**East Anglia One North (EA1N) and East Anglia Two (EA2) Offshore Wind Farms**

**Planning Inspectorate Reference: EA1N – EN010077 & EA2 – EN010078**

**East Suffolk Council's Summary of Oral Case - Issue Specific Hearing 7**

ESC Summary of Oral Case - Issue Specific Hearing 7 (17 February 2021) – Biodiversity and Habitat Regulations Assessment

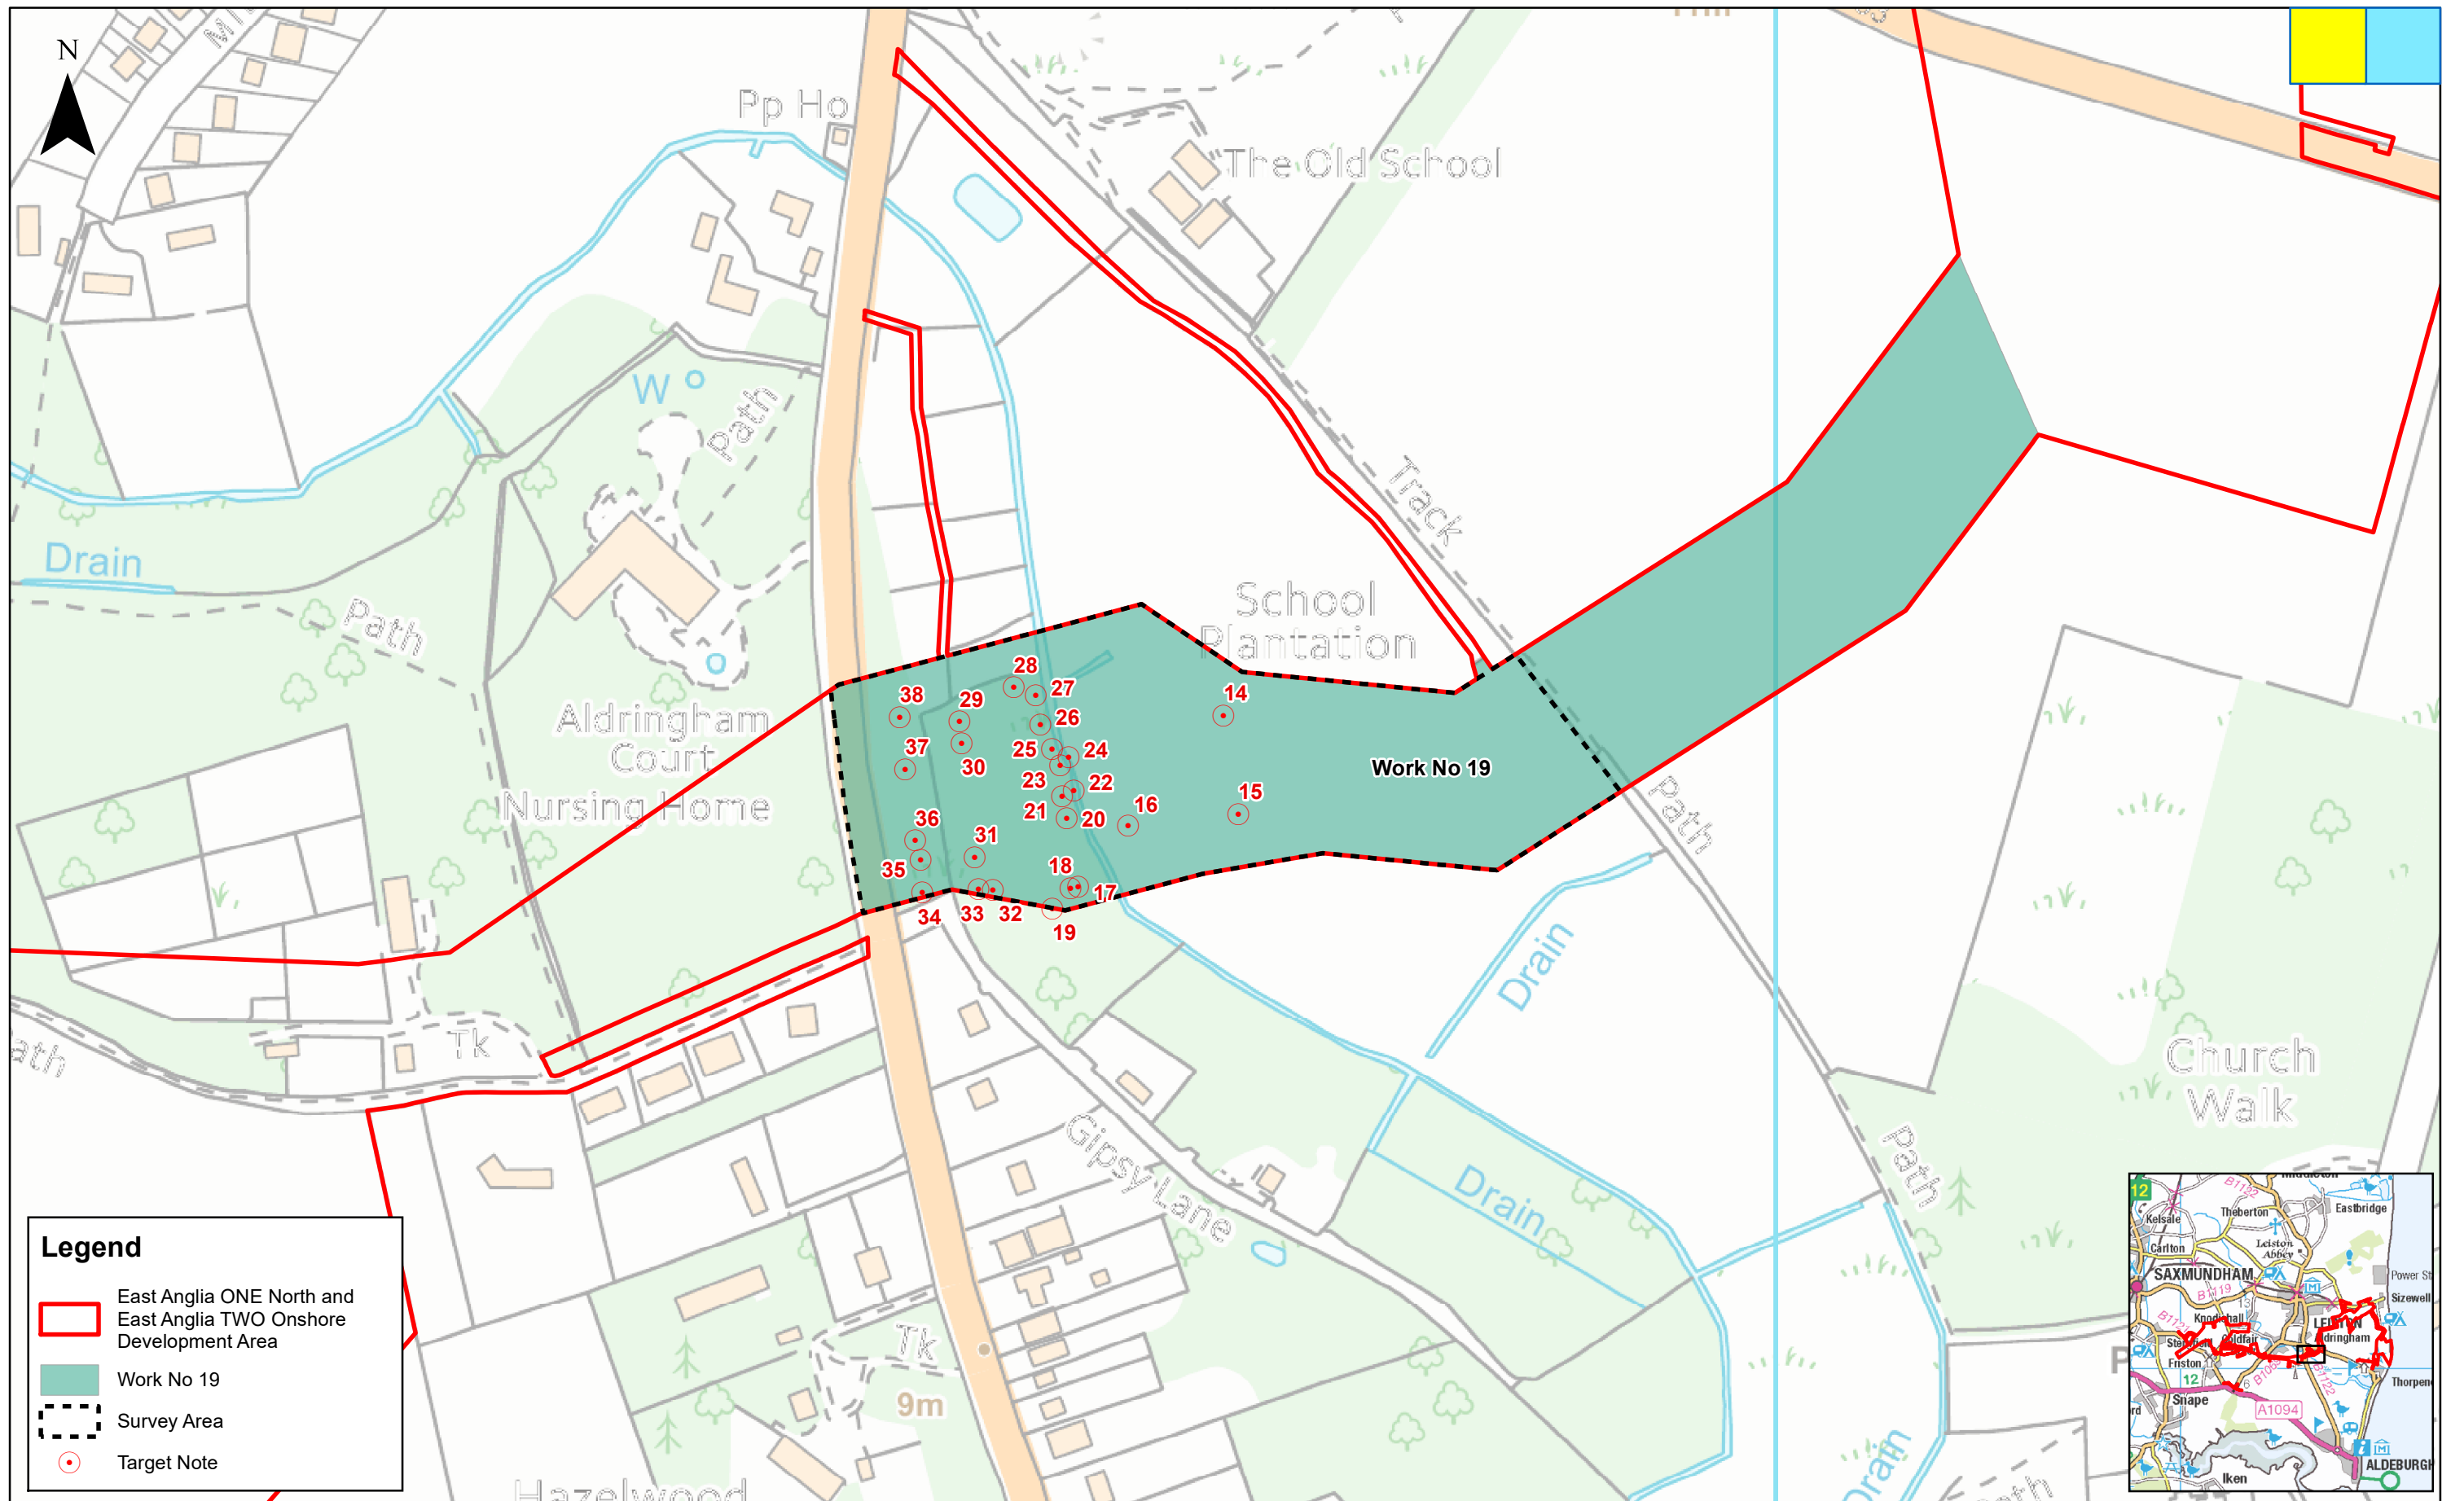
<p>Priority Habitat Inventory. Whilst it is acknowledged that the area is proposed to be partially crossed with a narrowed working width (16.1m/27.1m), nevertheless if open cut trenching is utilised then there will be loss of a UK Priority habitat in this area.</p> <p>The mitigation hierarchy must be applied in considering this impact. If the impact cannot be avoided or fully mitigated (e.g. by the use of an alternative crossing construction technique) then it must be compensated. We understand that compensation planting is proposed (in Work No.24). Please see our comments in relation to b) v. below on this.</p> <p>ii. ESC has no specific comments on this point. This is a concern which has been raised by Natural England.</p> <p>iii. As set out in our Deadline 4 comments [REP4-059], ESC’s main concern with the proposed crossing of the Hundred River (in the absence of a viable trenchless crossing construction</p>	<p>ii. N/A</p> <p>iii. East Suffolk Council Deadline 4 Submission - Comments on the Applicants Deadline 3 submission [REP4-059]</p>

<p>method) is the working width stated as required. If it is accepted that a trenchless crossing technique is not feasible in this location, then any open cut crossing width must be kept to the absolute minimum. At present, whilst the Outline Watercourse Crossing Method Statement (OWCMS) [REP3-048] commits to a narrowed working width for both projects through the western woodland area it is not clear why a similar reduction cannot be achieved at the crossing if the ducts for both projects can be constructed together (as proposed at the SPA Crossing)? The requirement for each project to have a 40m crossing which is then doubled to account for both projects appears unnecessarily large, particularly when in other sensitive locations a combined width of 27.1m is being achieved.</p>	<p>Deadline 3 Submission - EA2 Outline Watercourse Crossing Method Statement - Version 01 [REP3-048]</p>
<p>b) Other terrestrial ecology</p> <ul style="list-style-type: none"> <li>i. Bats</li> <li>ii. Badgers</li> <li>iii. Noise</li> <li>iv. Air Quality</li> <li>v. Trees and hedgerows</li> <li>vi. Ecological enhancement</li> </ul>		<p>i. Bats – ESC’s primary concern for this receptor is the loss of hedgerows during construction and subsequent impact on bat commuting and foraging routes. We welcome the ongoing discussion with the Applicants on this matter and note</p>	<p>i. Deadline 3 Submission - 8.7 Outline Landscape and Ecological Management Strategy (Clean) - Version 02 [REP3-030]</p> <p>Deadline 5 Submission - EA1N&amp;EA2 Applicants' Comments on ESC's Deadline 4 Submissions [REP5-010]</p>
